Public Consultation  
Submission Report  
– 1st Non-Statutory  
Public Consultation

# BusConnects Dublin Core Bus Corridor Projects

## Corridor 1 – Clongriffin to City Centre

### Emerging Preferred Route – Public Consultation Report 2018/2019

CLONGRIFFIN TO CITY CENTRE CORE BUS CORRIDOR SCHEME  
JUNCTION SYSTEMS DESIGN  
CLAREHALL

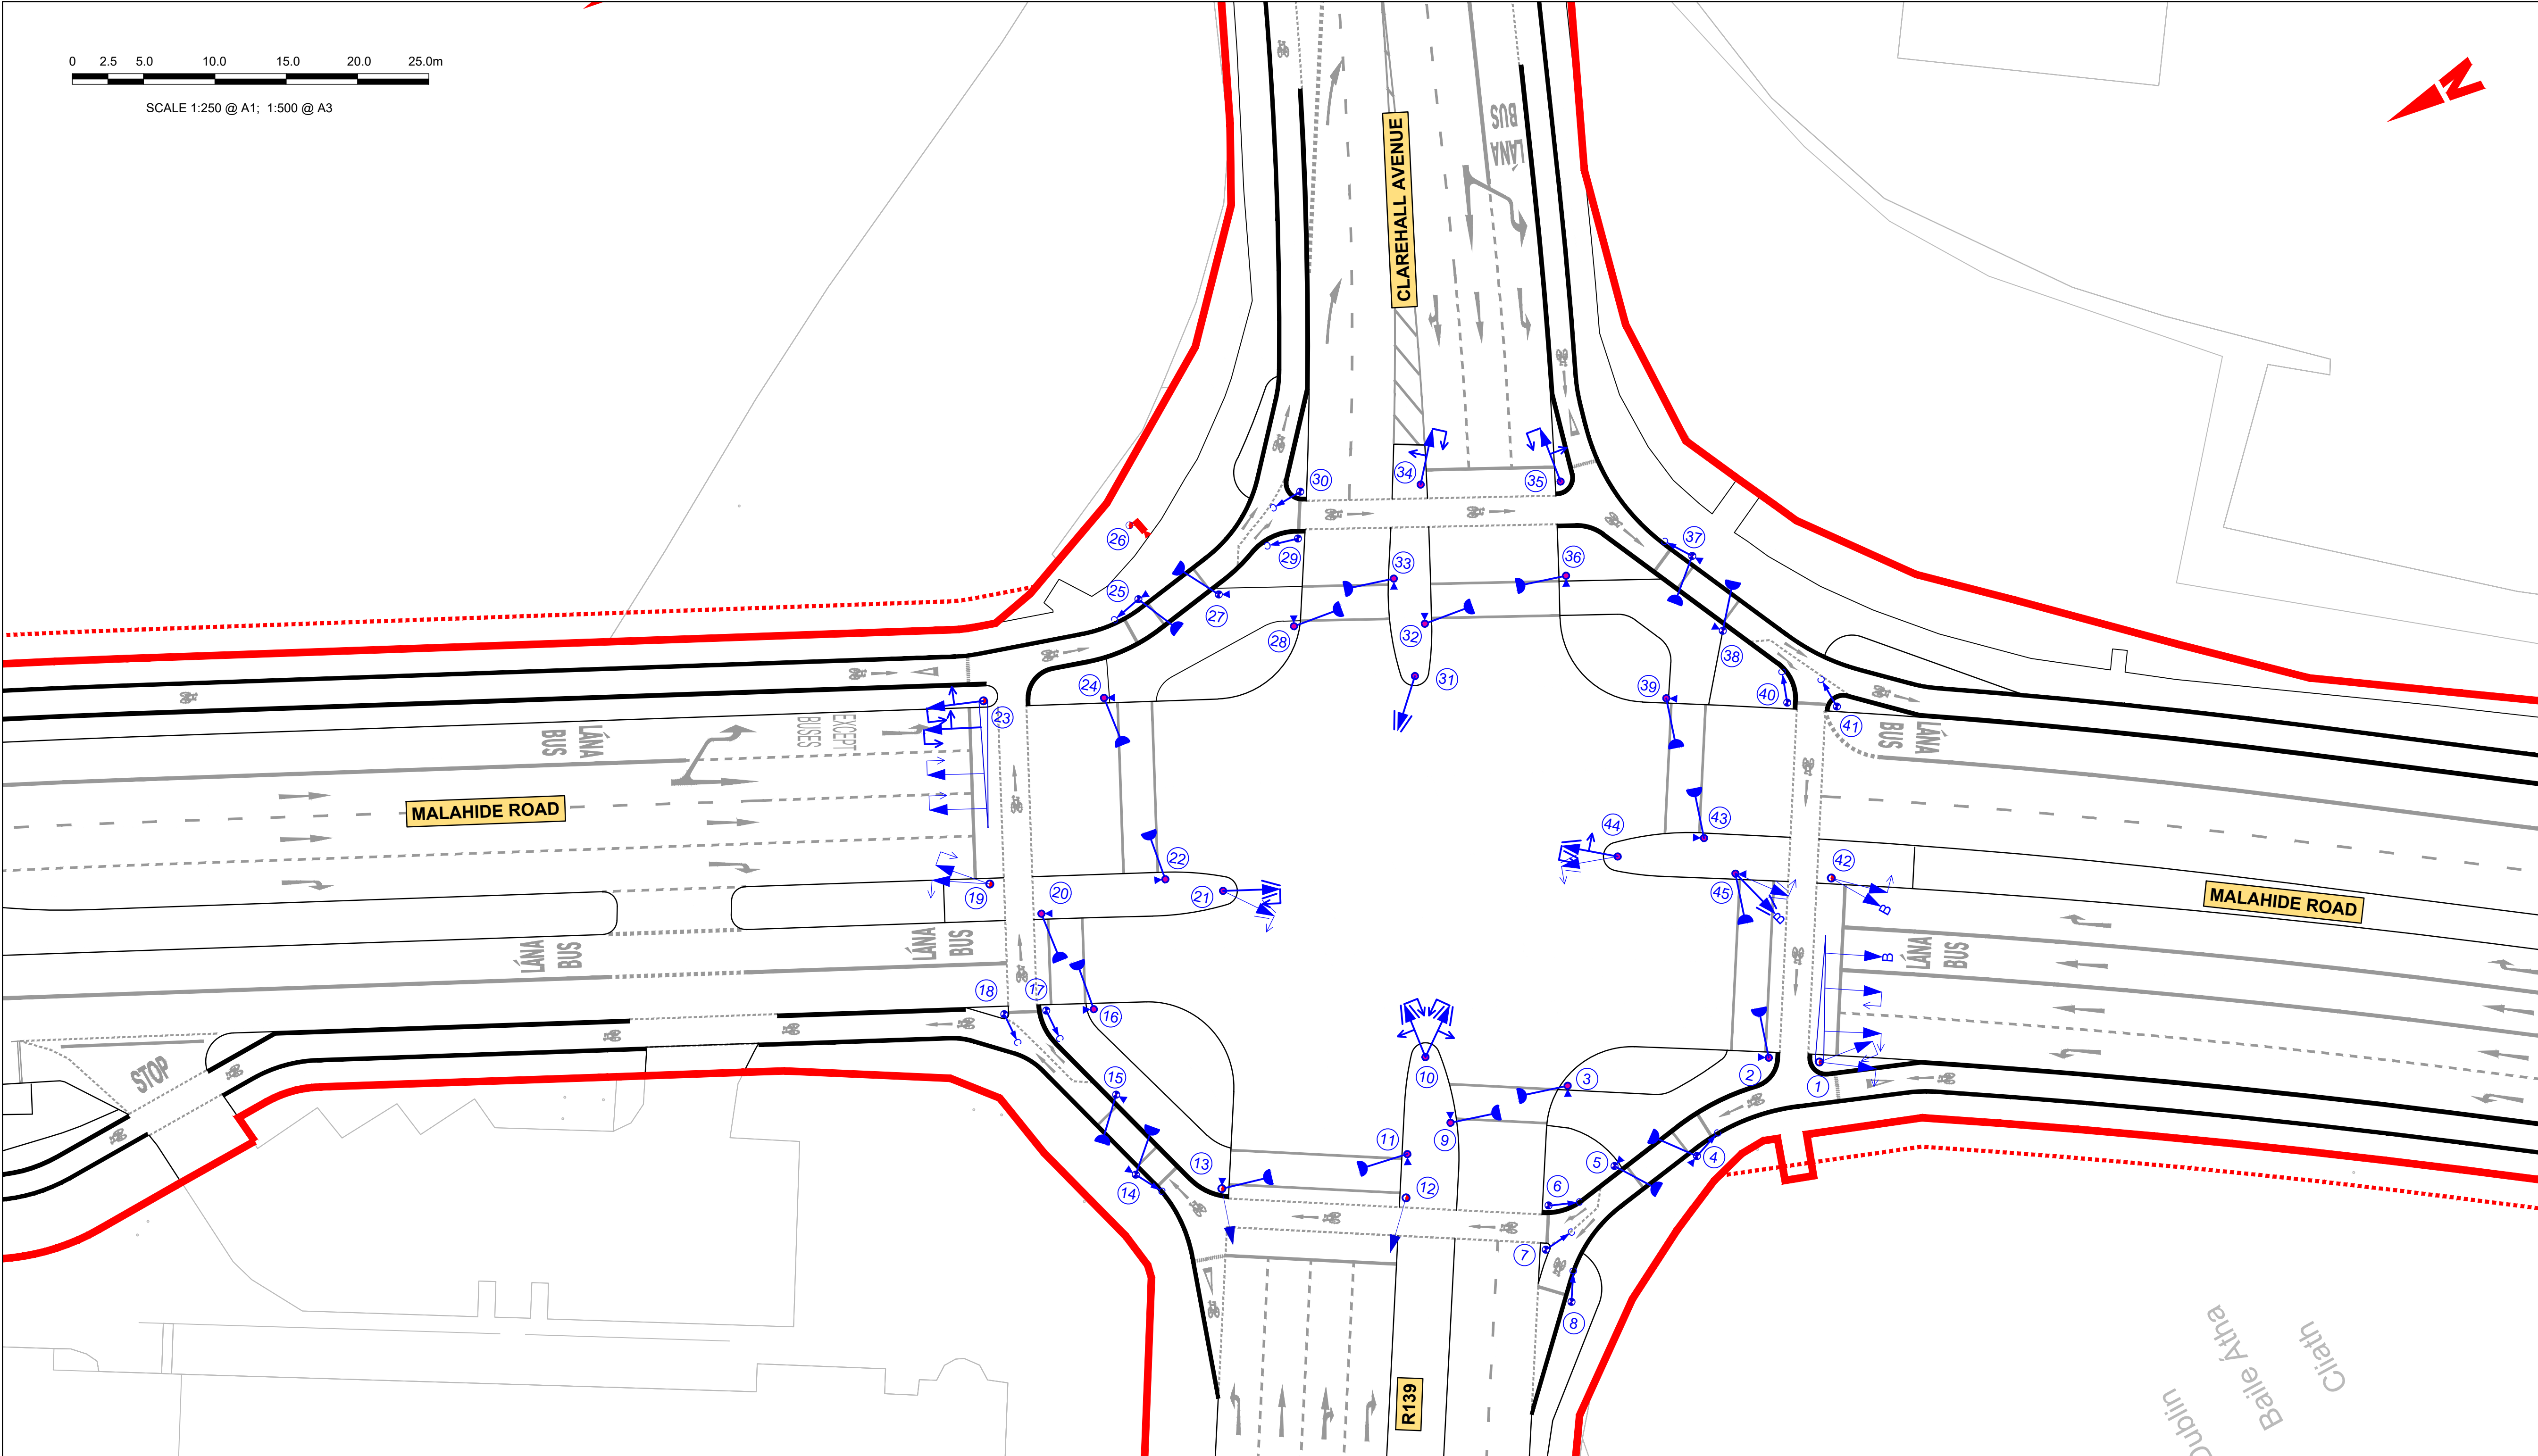
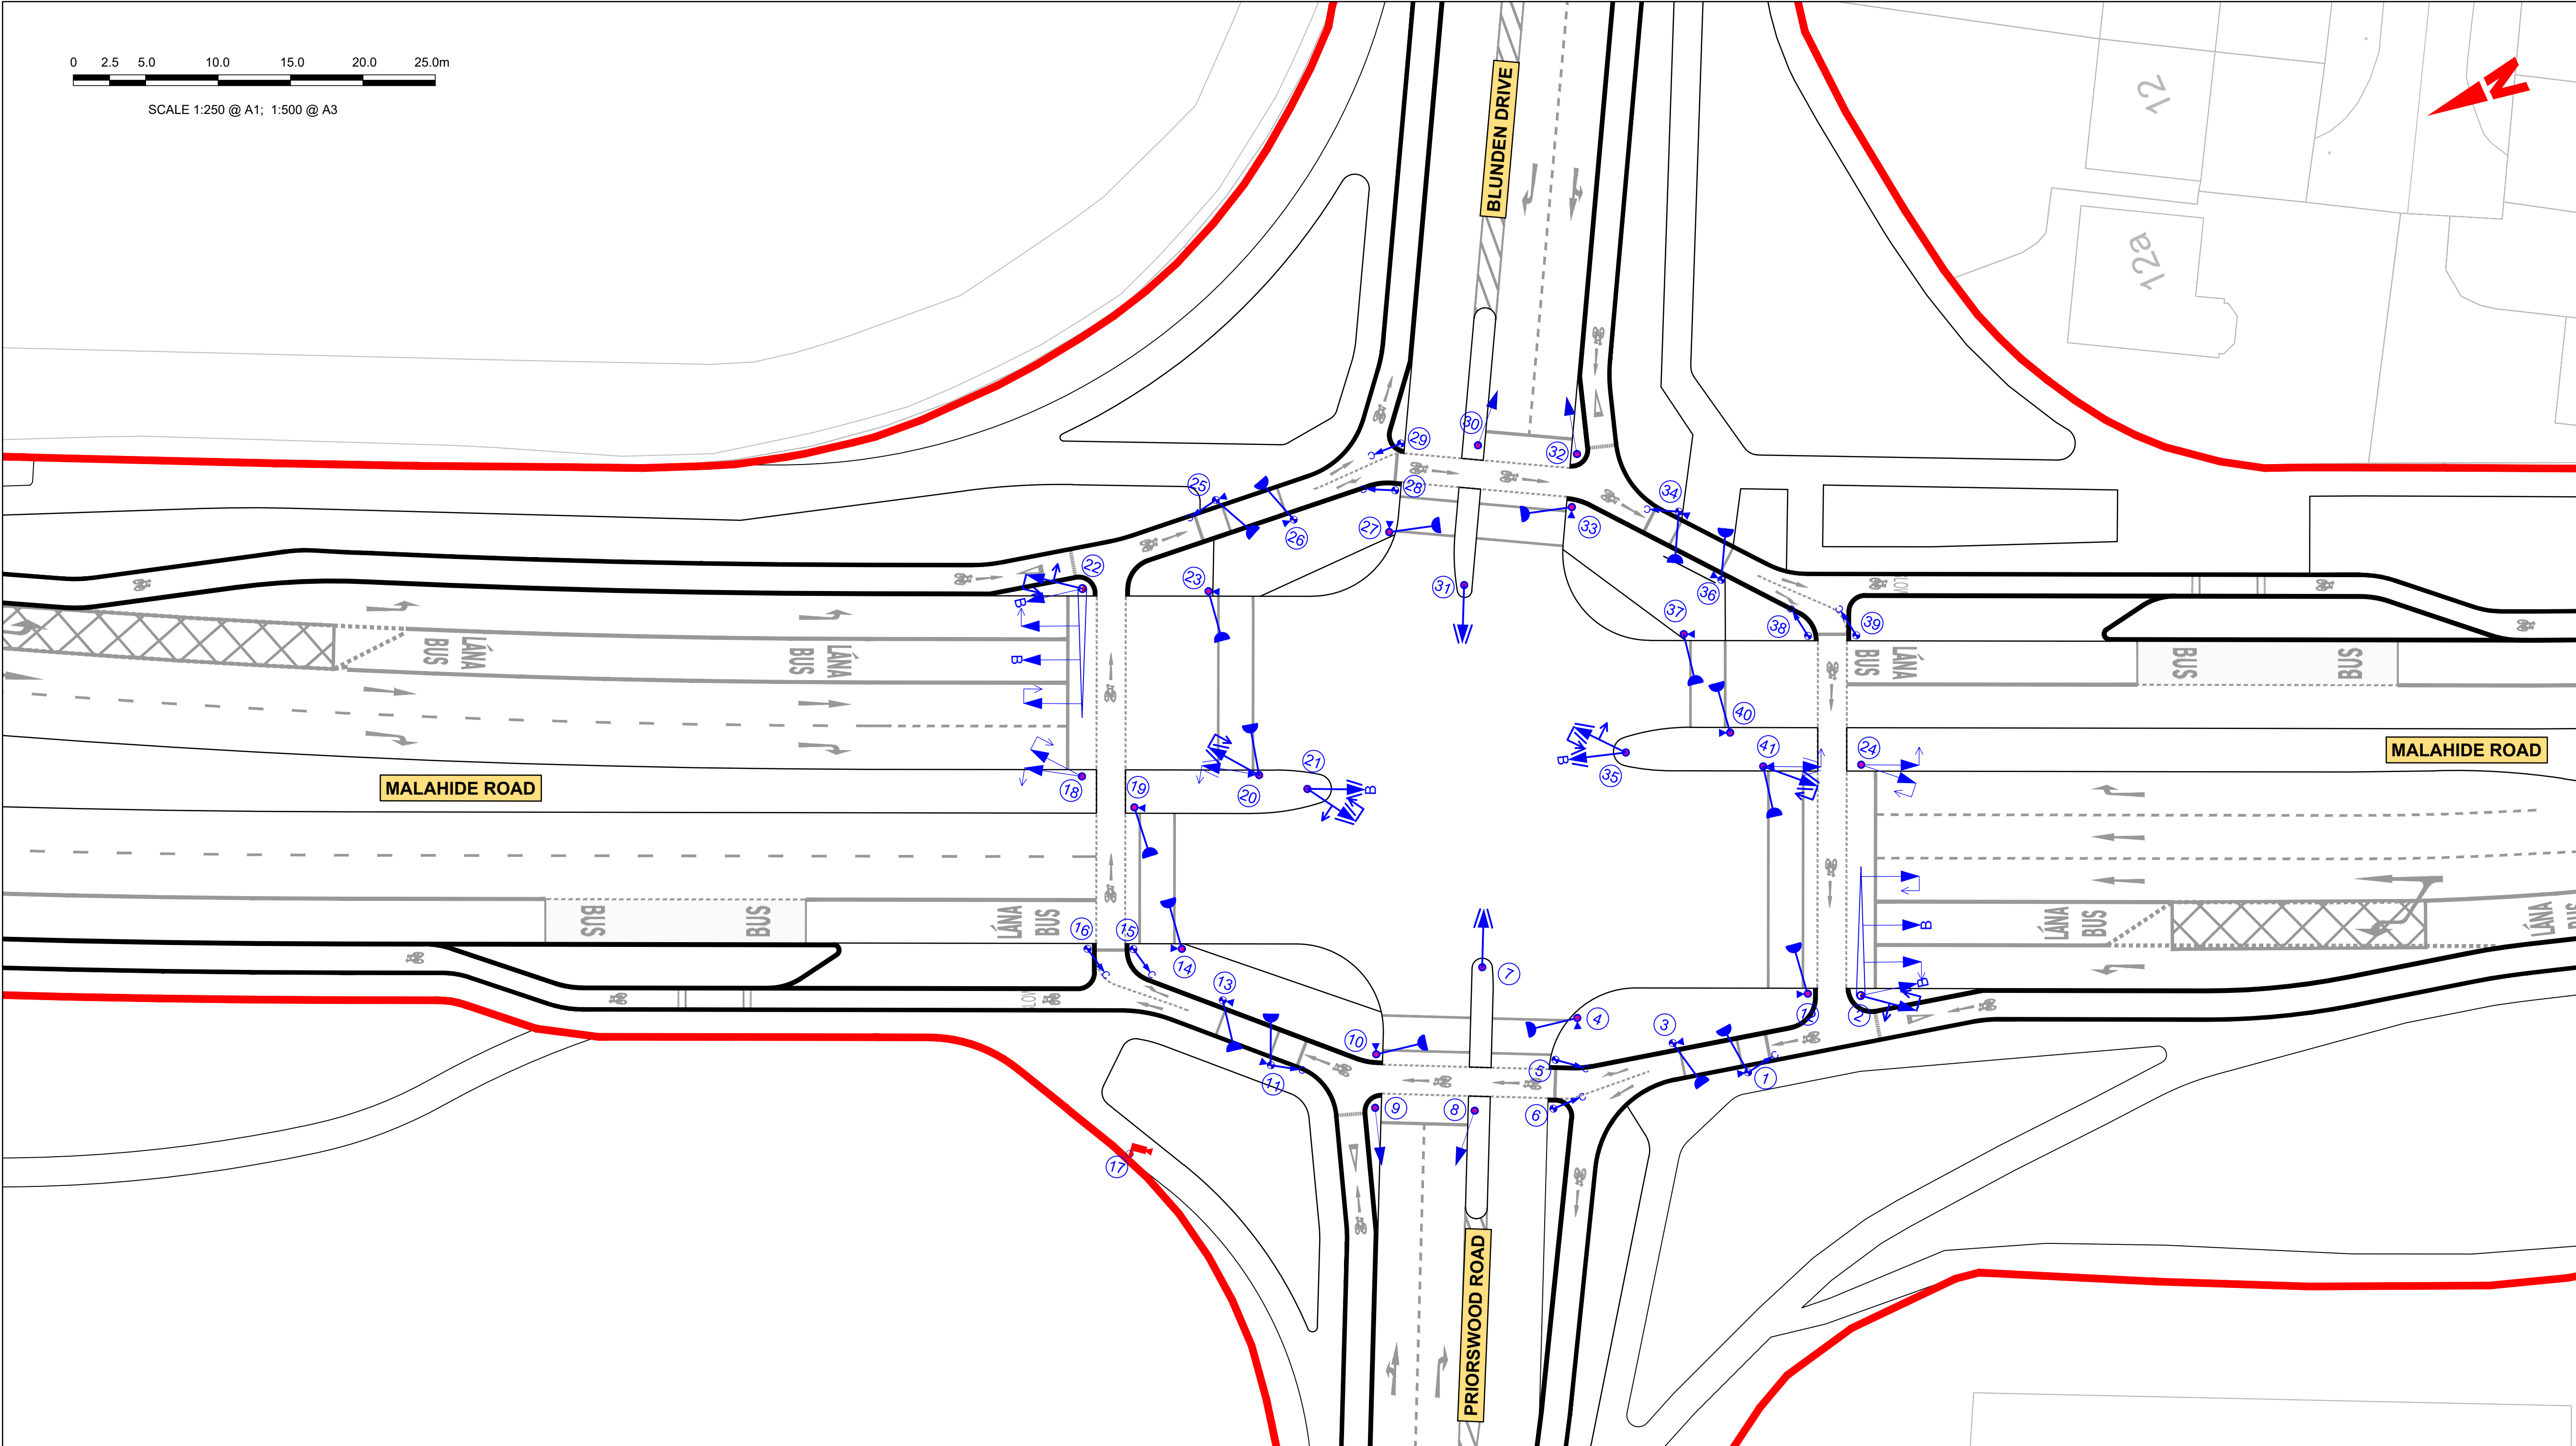
Concerns were raised for the safety of cyclists at the following junctions: Clarehall Avenue/ Malahide Road, Blunden Drive/ Malahide Road, the Artane Junction, and Tonlegee Road/ Malahide Junction. A Dutch-Style Junction should be considered at these locations to ensure safety for all road users. Currently it is possible for cyclists to travel freely in all directions at the Artane Junction (shown on NTA maps 13 and 14). The new design will make it impossible for a cyclist to safely travel straight ahead from Gracefield Road to Ardlea Road, nor safely make a right turn from any arm.

The designs at this stage of planning are preliminary in nature, and will require significant additional work to bring them to a point where the NTA is prepared to submit the overall proposal for planning consent. The various issues raised in this consultation process will also feed into the designs.
